COMMUNITY SERVICES DEPARTMENT

Subject: Forest Lakes Filing No. 6 Final Plat, Review #2 (SF-20-027)

Forest Lakes Filing No. 6 Final Plat Development Application Review

FOREST LAKES FILING NO. 6

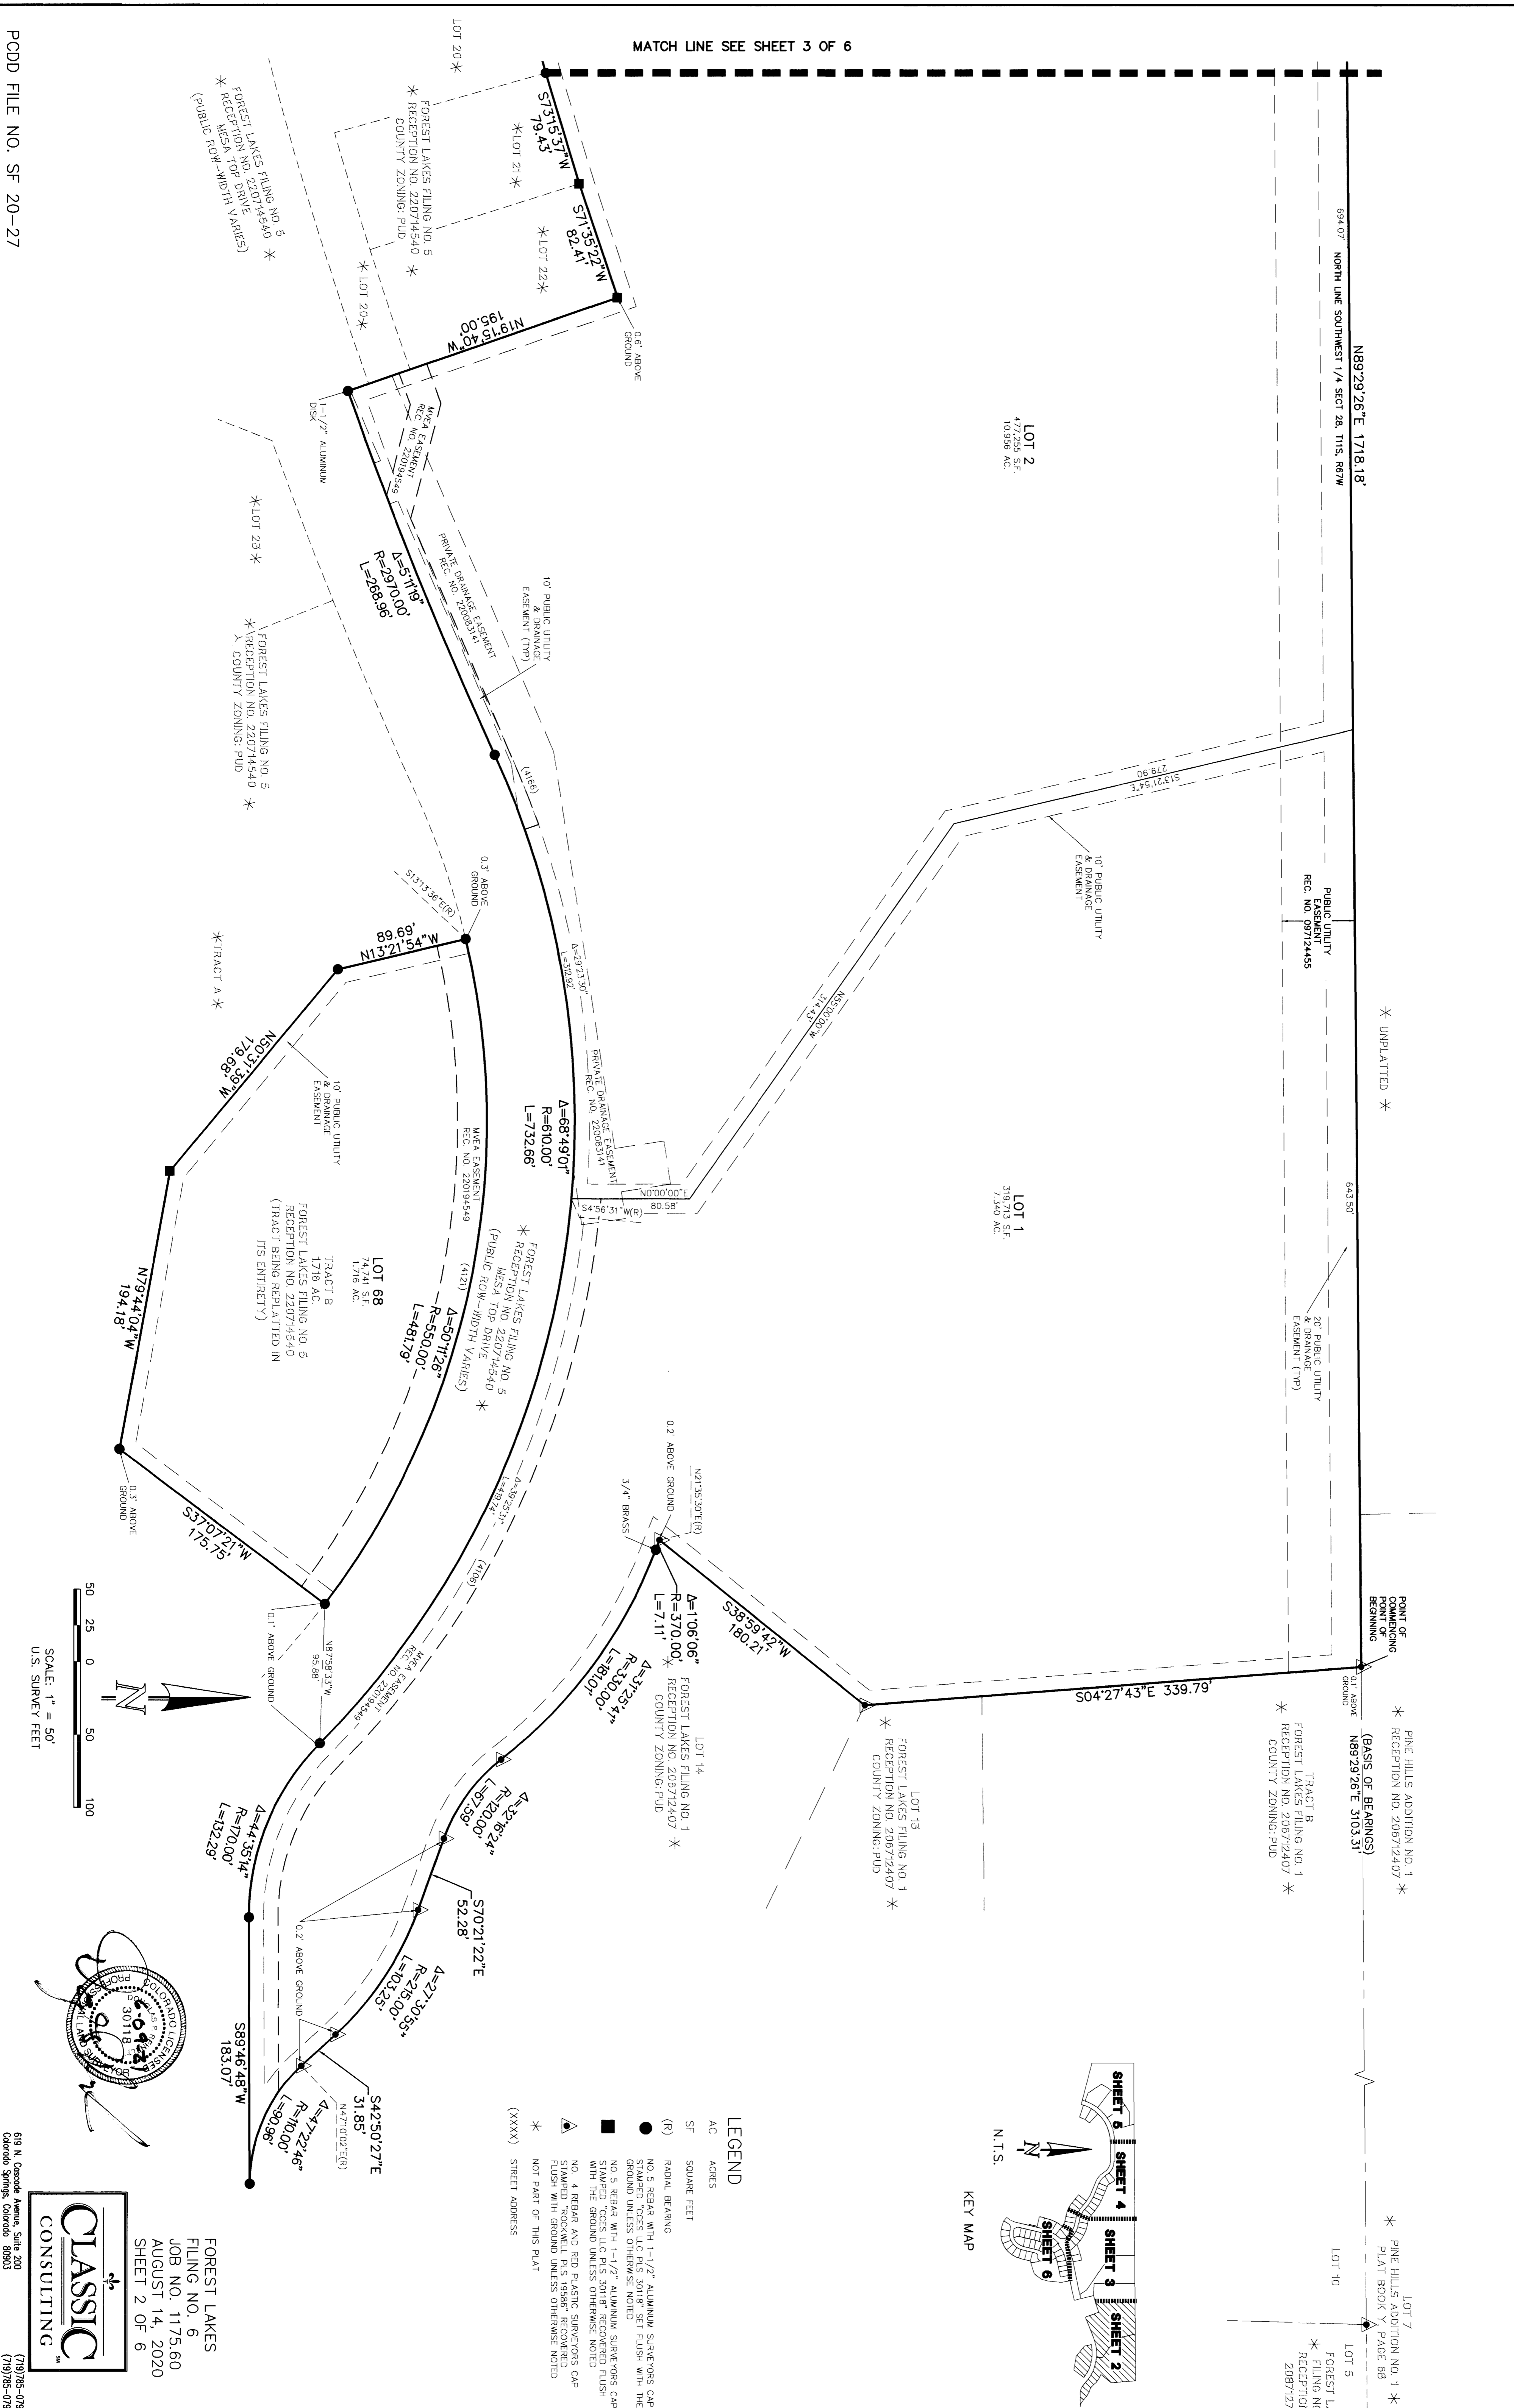
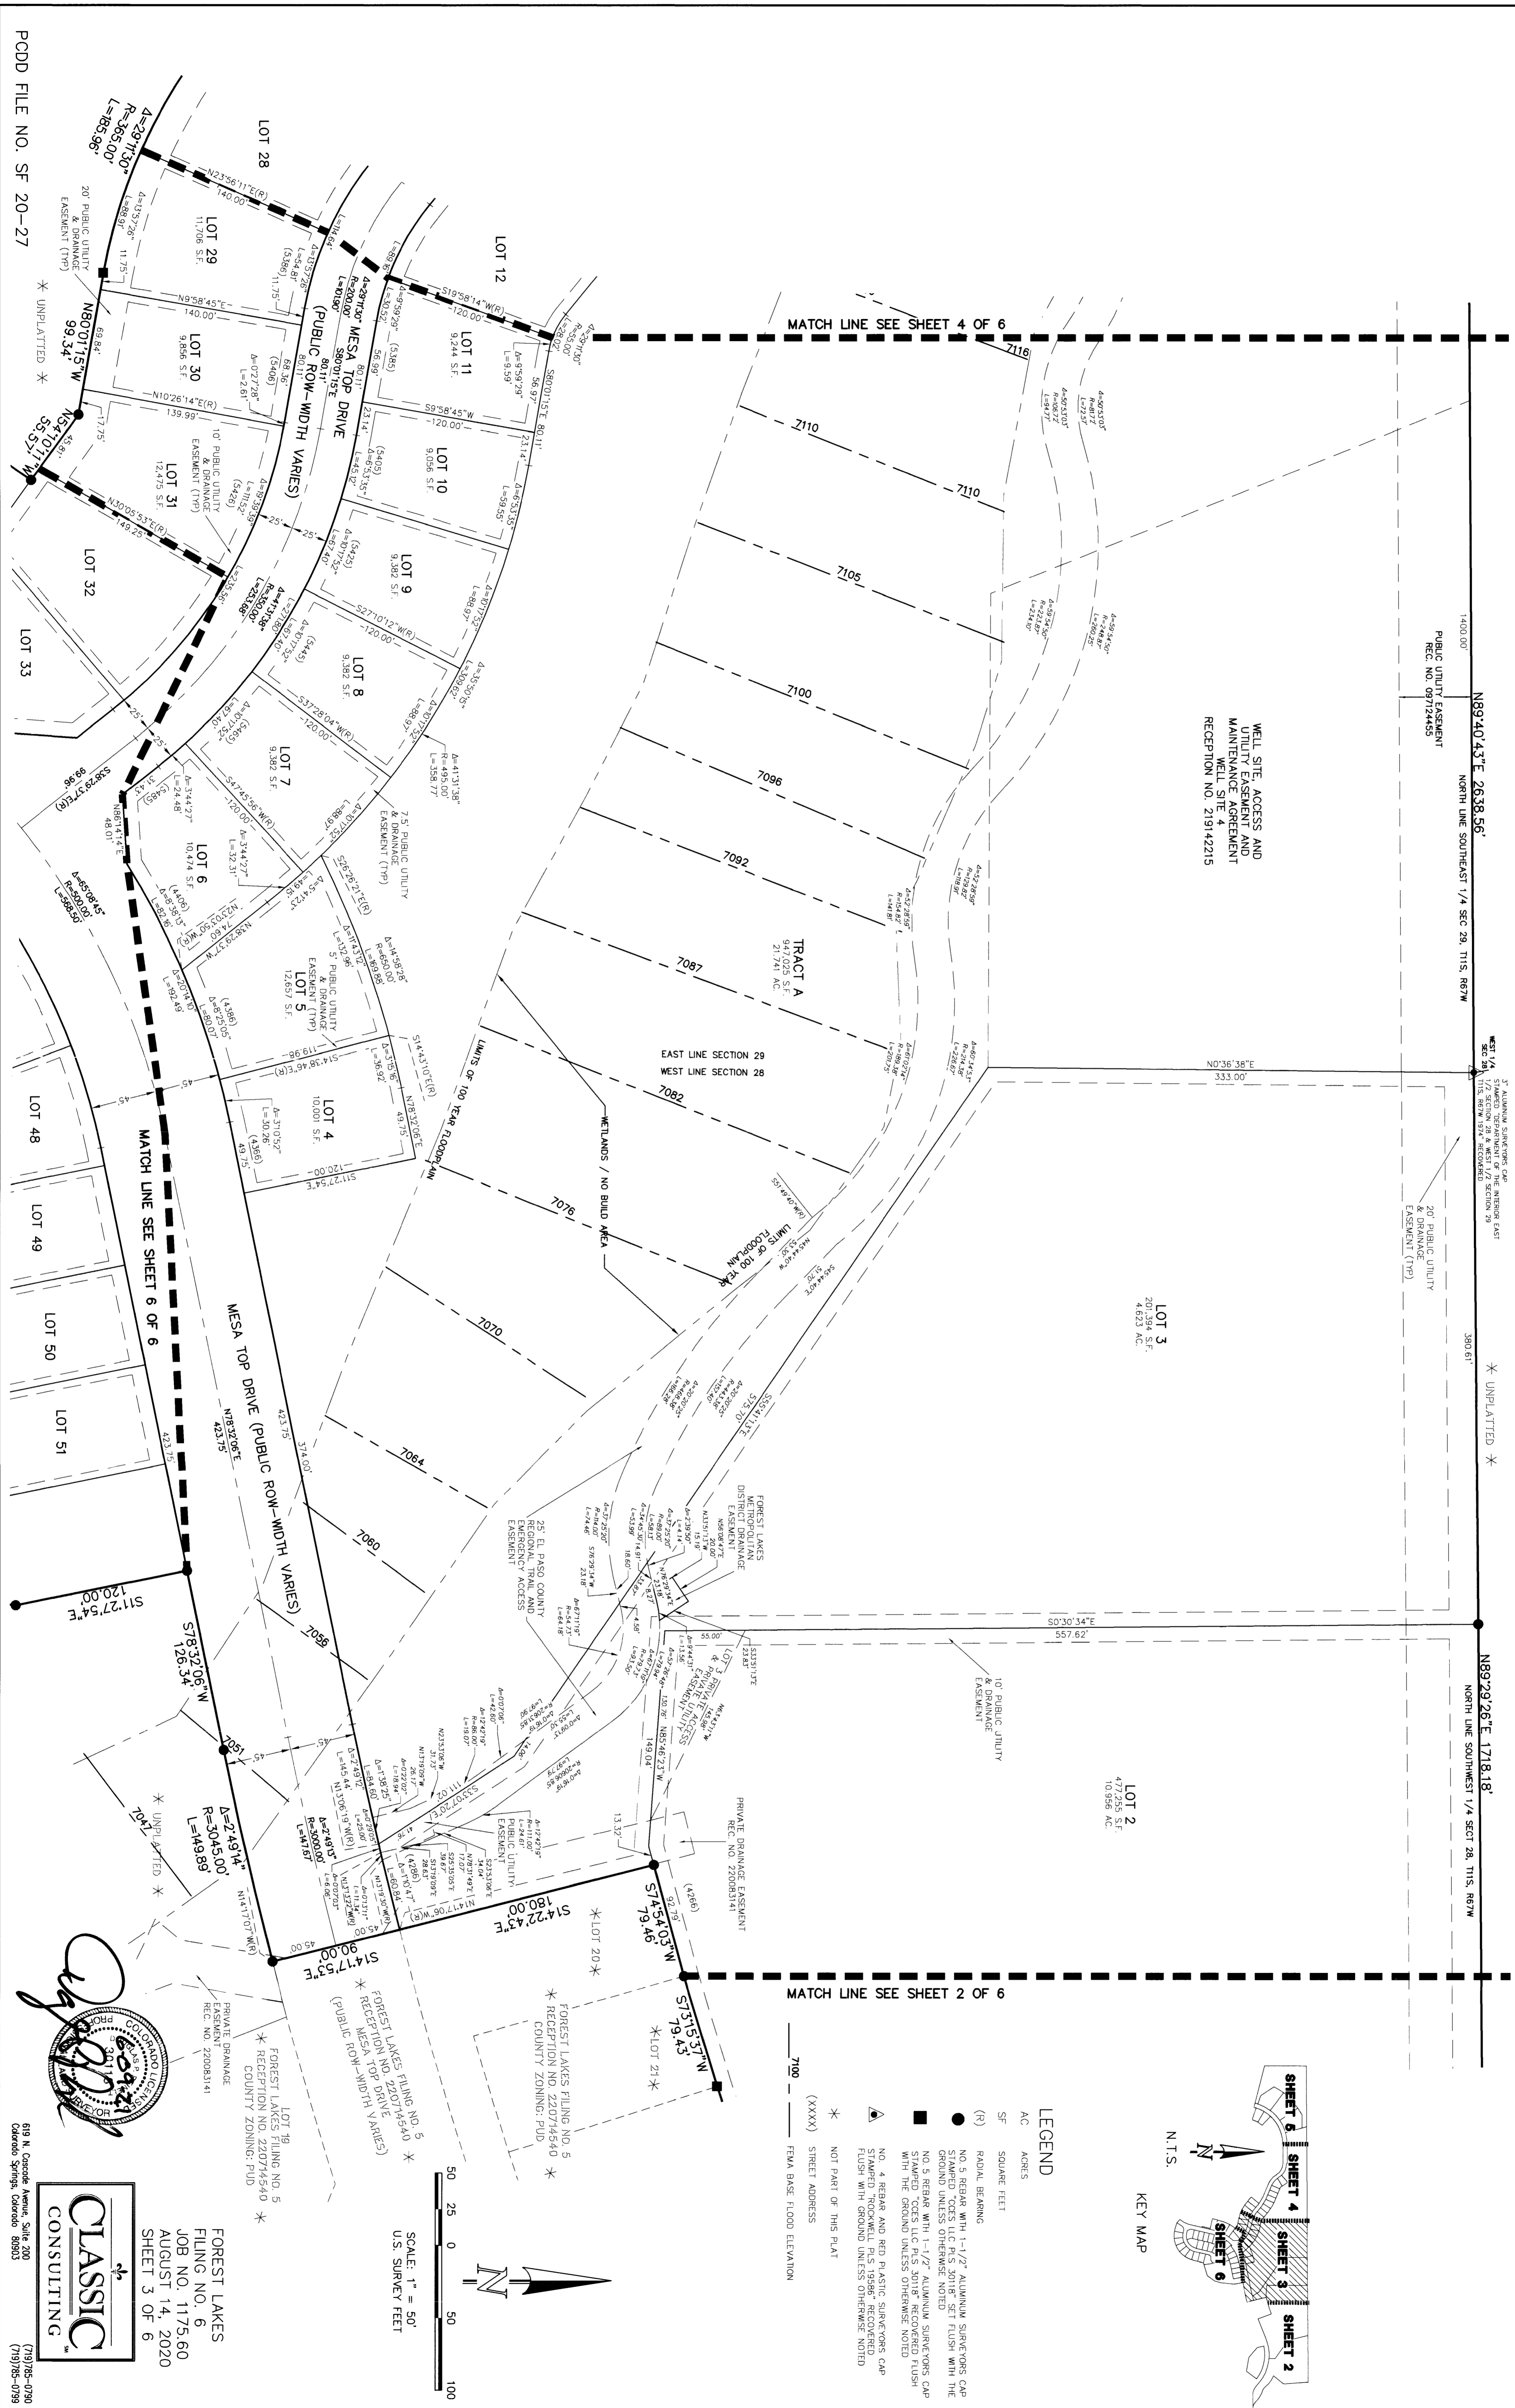
The BoCC-approved Forest Lakes Phase II PUD Preliminary Plan shows in detail the Forest Lakes Secondary Regional Trail, as well as the internal trail network and emergency access road. However, the Forest Lakes Filing No. 6 Final Plat does not show the 25-foot trail easement through the project site, and

the Final Plat notes do not reference the dedication of the trail easement to El Paso County. As such, staff recommends that the applicant include the easement alignment in the Final Plat drawings and include language in the Final Plat General Notes that designates and provides to El Paso County a 25-foot trail easement through Forest Lakes Filing No. 6, within Tracts A and B, that allows for public access of the Forest Lakes Secondary Regional Trail, and dedicate the aforementioned easement to El Paso County prior to the recording of the Final Plat.

The Park Advisory Board recommends that the Planning Commission and the Board of County Commissioners include the following conditions when considering and/or approving the Forest Lakes Filing No. 6 Final Plat: (1) designate and provide to El Paso County a 25-foot trail easement through Forest Lakes Filing No. 6 Final Plat, within Tracts A and B, that allows for public access of the Forest Lakes Secondary Regional Trail, and dedicate the easement to El Paso County within the Final Plat General Notes prior to the recording of the Final Plat; (2) regional park fees are not required pursuant to the existing Forest Lakes Phase I PUD Preliminary Plan and Filing No. 1 Final Plat recommended and endorsed motions; (3) the section of the Forest Lakes Secondary Regional Trail located within Filing No. 6 shall be constructed within two years of the recording of the Final Plat; (4) trail plans shall be submitted to and approved by County Parks prior to construction; (5) the trail shall be constructed to Tier 1 standards for a regional trail; (6) the trail shall be maintained by the Forest Lakes Metropolitan District when contained within developer-owned tracts, while El Paso County agrees to maintain the Regional Trail when contained within dedicated roadway rights-of-way; (7) require fees in lieu of land dedication for urban park purposes in the amount of \$20,060. A Park Lands Agreement may be an acceptable alternative to urban park fees, provided the agreement is approved by the County and executed prior to recording the Final Plat."
